From: Fiona Fitzgerald
Sent: 15 August 2018 15:43
To: Anita Gardner
Subject: RE: Waterbury House; Planners comments F/10/18/PL

Thank you for forwarding the agent's response. The fact still remains that with the exception of 'night-time with windows closed' noise levels will not achieve the levels set in BS8233. Further, even with an acoustic fence, the external levels will only just achieve the 'serious annoyance' level.

Therefore I would still recommend **refusal** on this basis.

L_{Aeq} , L_{Amax} and L_{A90} Noise Levels

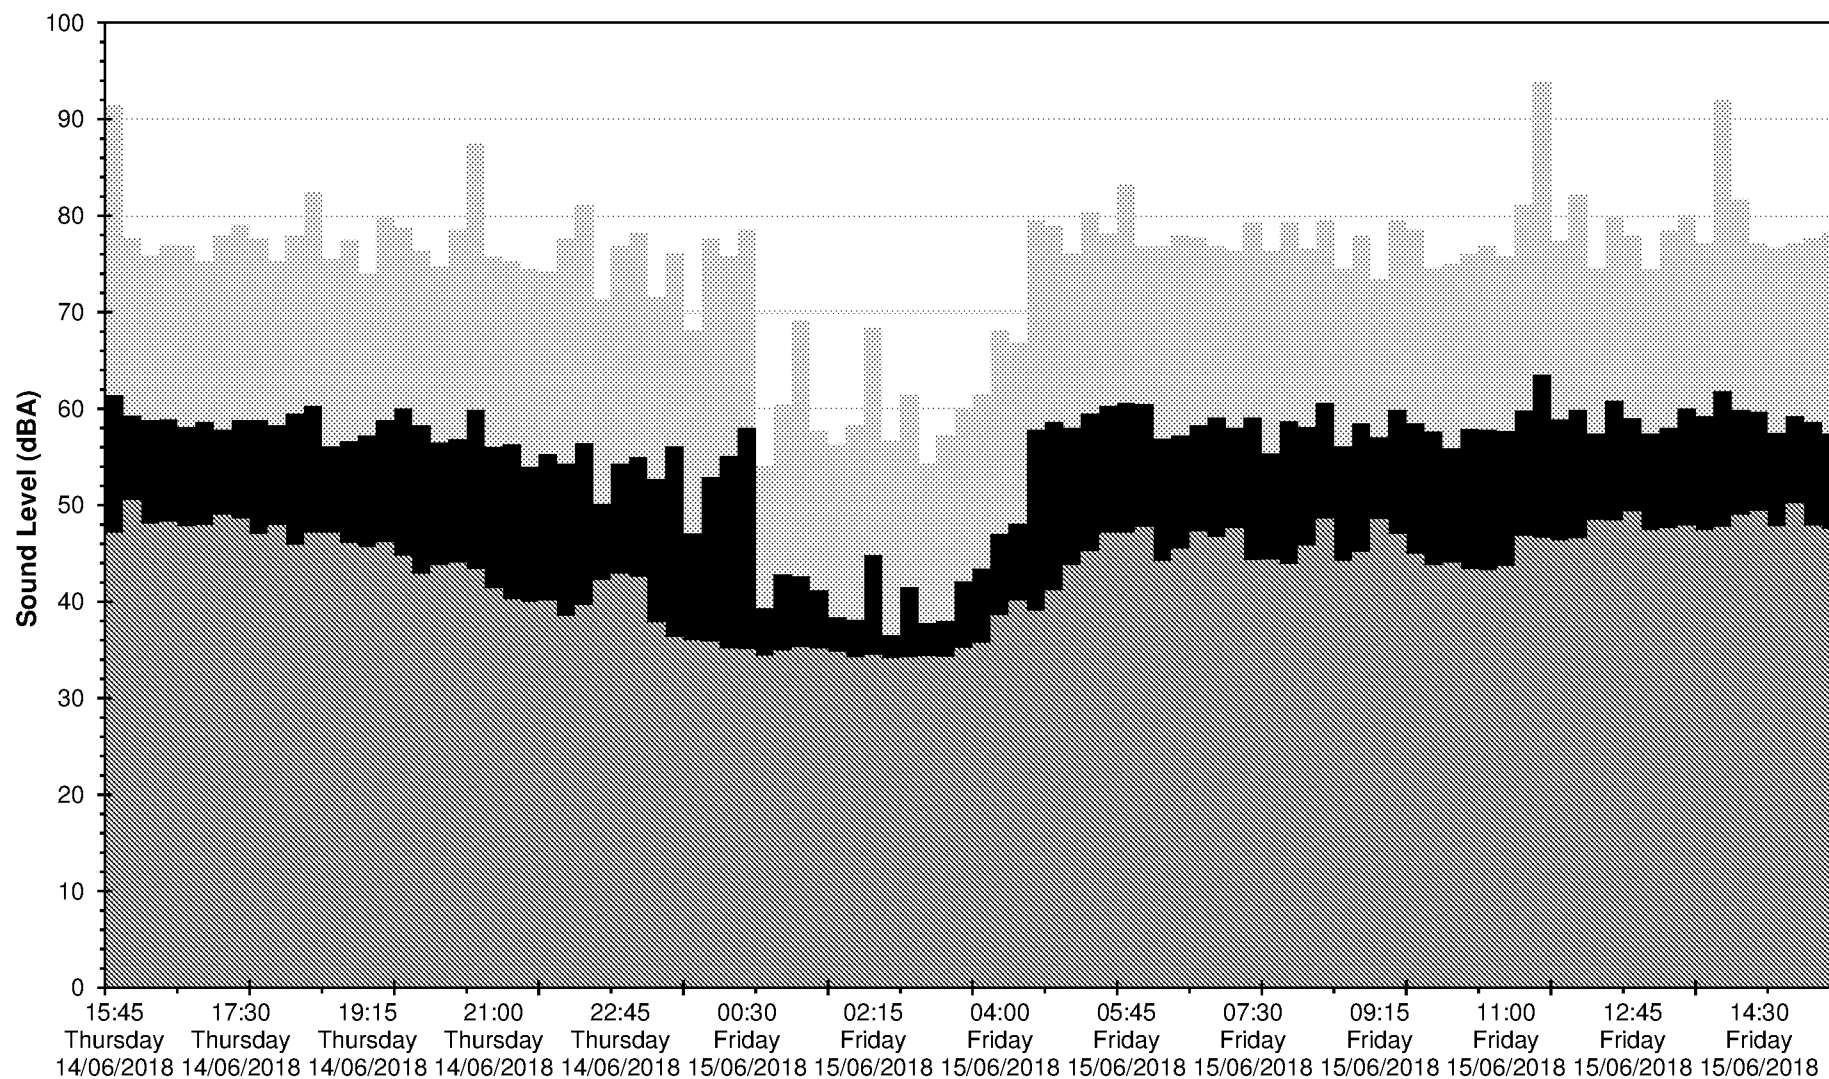
2. No raw data was submitted. It is not typically necessary to provide raw data for noise surveys. We include a time history graph illustrating our measurement data, which describes the noise environment at the measurement position during the survey. We undertake hundreds of surveys every year and this is not unusual.

3. Due to the lack of raw data it has not been possible to determine how many exceedances of the 45dB (L_{Amax} night time) occur and therefore make a judgement on the actual number of exceedances. We have provided a glazing specification to provide a noise reduction of 34dB, which ensures the 45dB L_{Amax} level should not be exceeded more than 14 times during the night. This has been clarified in the attached revised copy of our report 25712/ADS1. We undertake hundreds of surveys every year and this is not unusual.
